## **Resubmittal Letter**

Project Address: 219 Harvell Rd, Coats NC, 27521, US

Project Name: Myron Adams Residence

PAGE NAME:
SITE PLAN

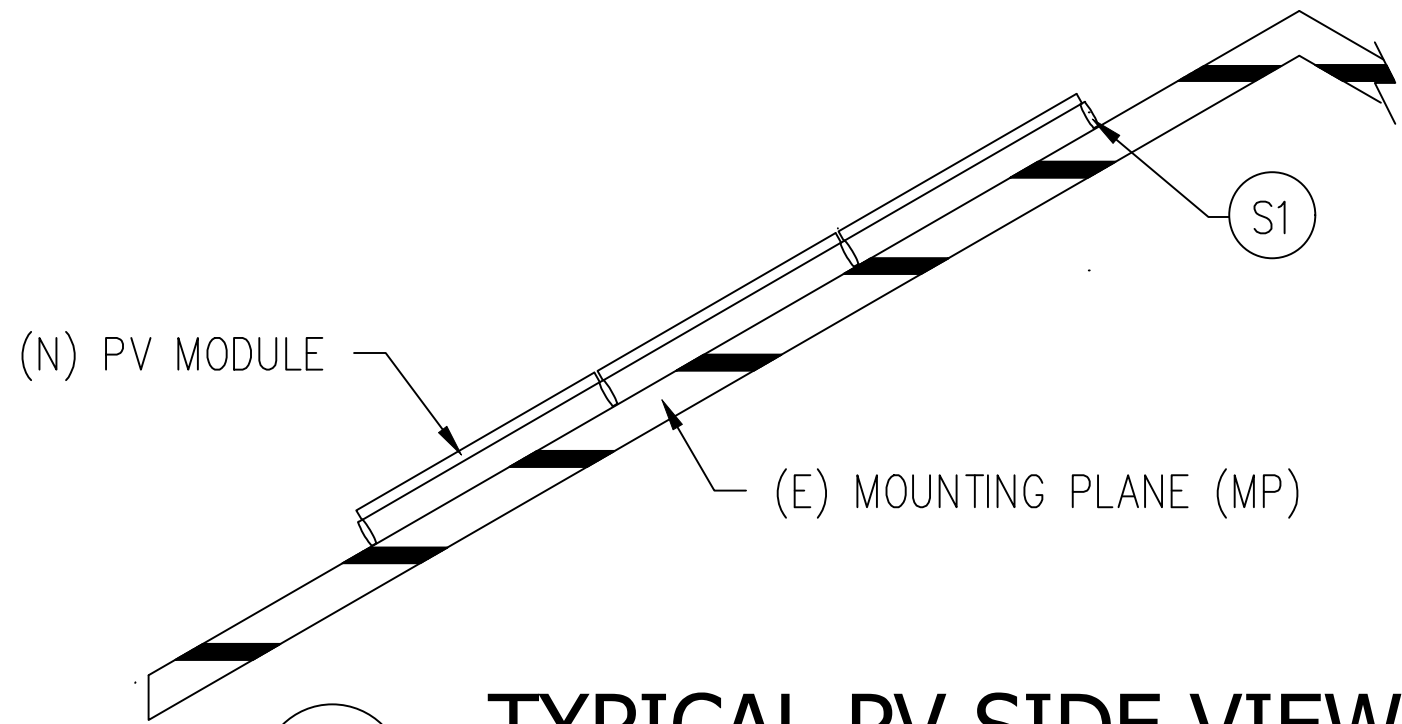
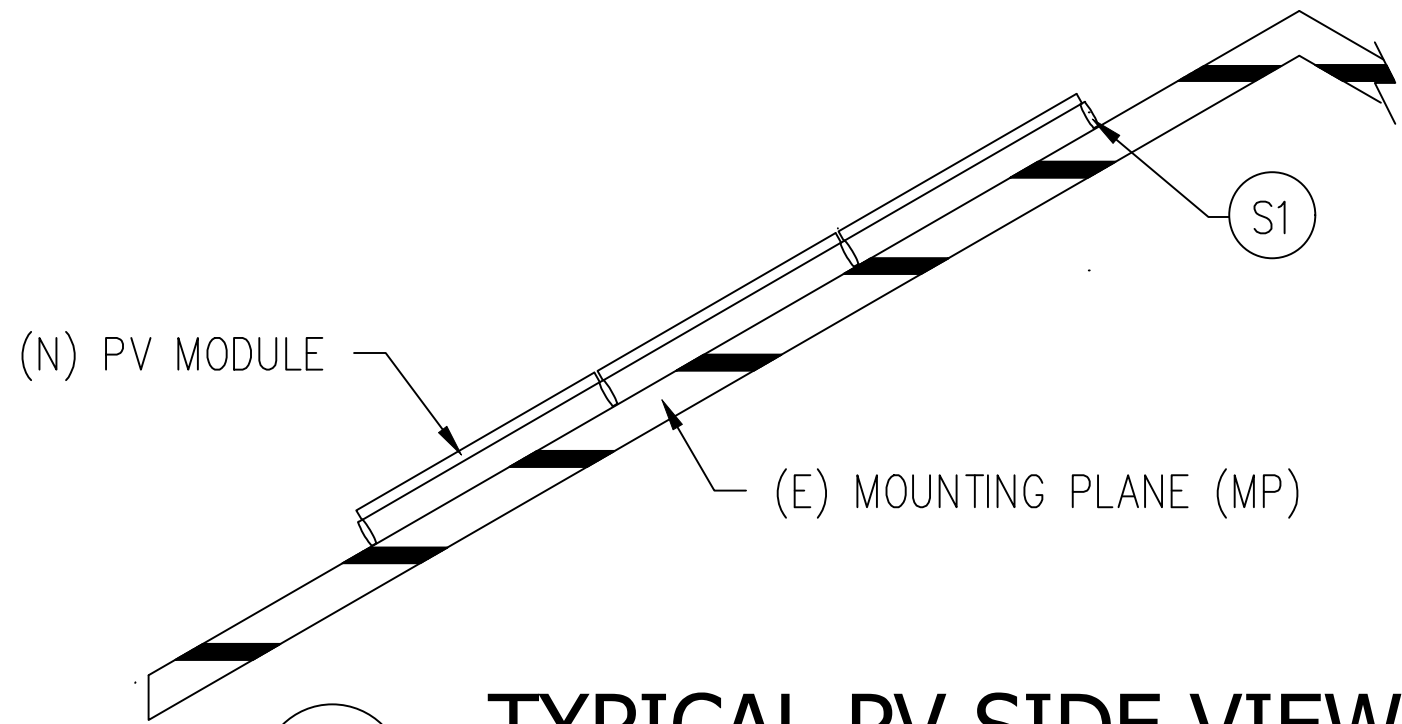
- a. Initial design had 4 PW3s to it. PW product has changed to comply with the Utility AC cap. PWs were changed to 2 PW+ and 2 PW2s.

DESCRIPTION: 14.985 KW PV ARRAY
 15.2 KW (AC NAMEPLATE) PV ARRAY
 54 KWH ENERGY STORAGE SYSTEM
 PAGE NAME: THREE LINE DIAGRAM

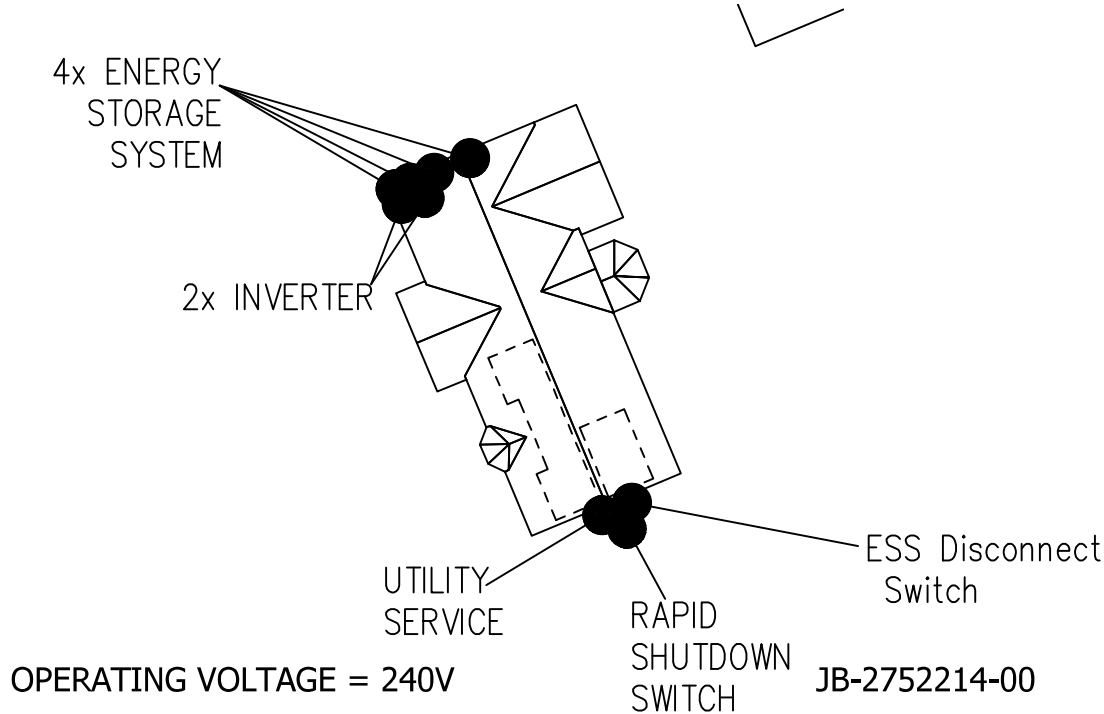
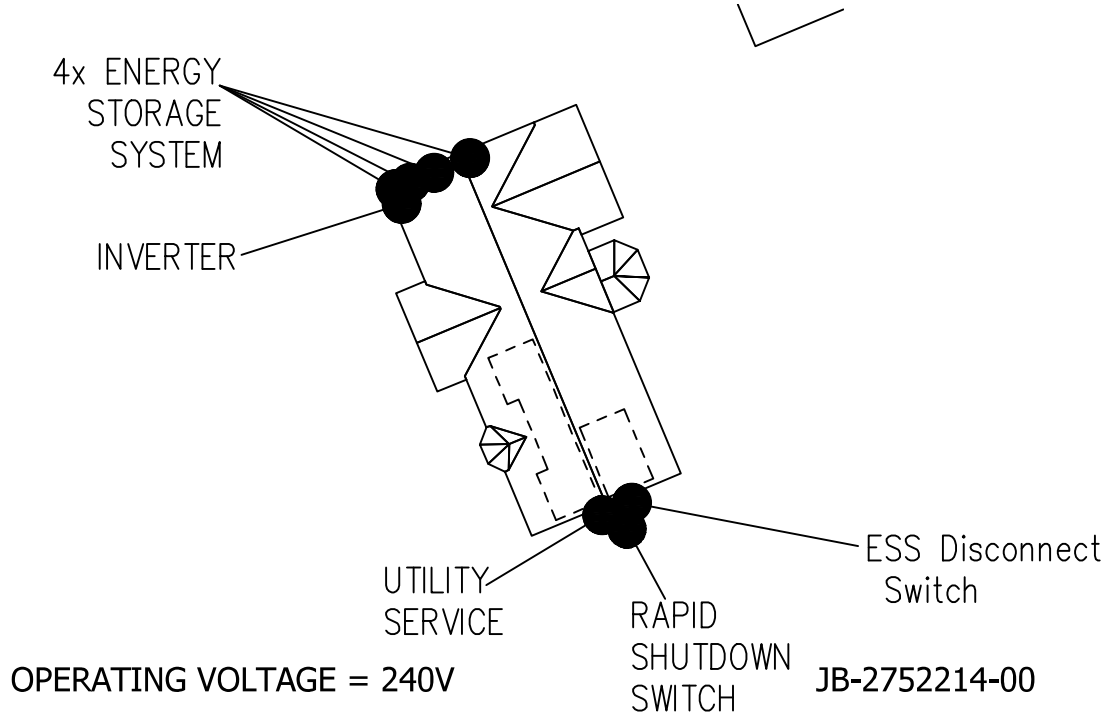
- b. PW product change also changes the load sizes which means the 400A LC is no longer needed. PWs will connect direct to the gateway.

- c. AC Disconnect fuses have been reduced to 175A.
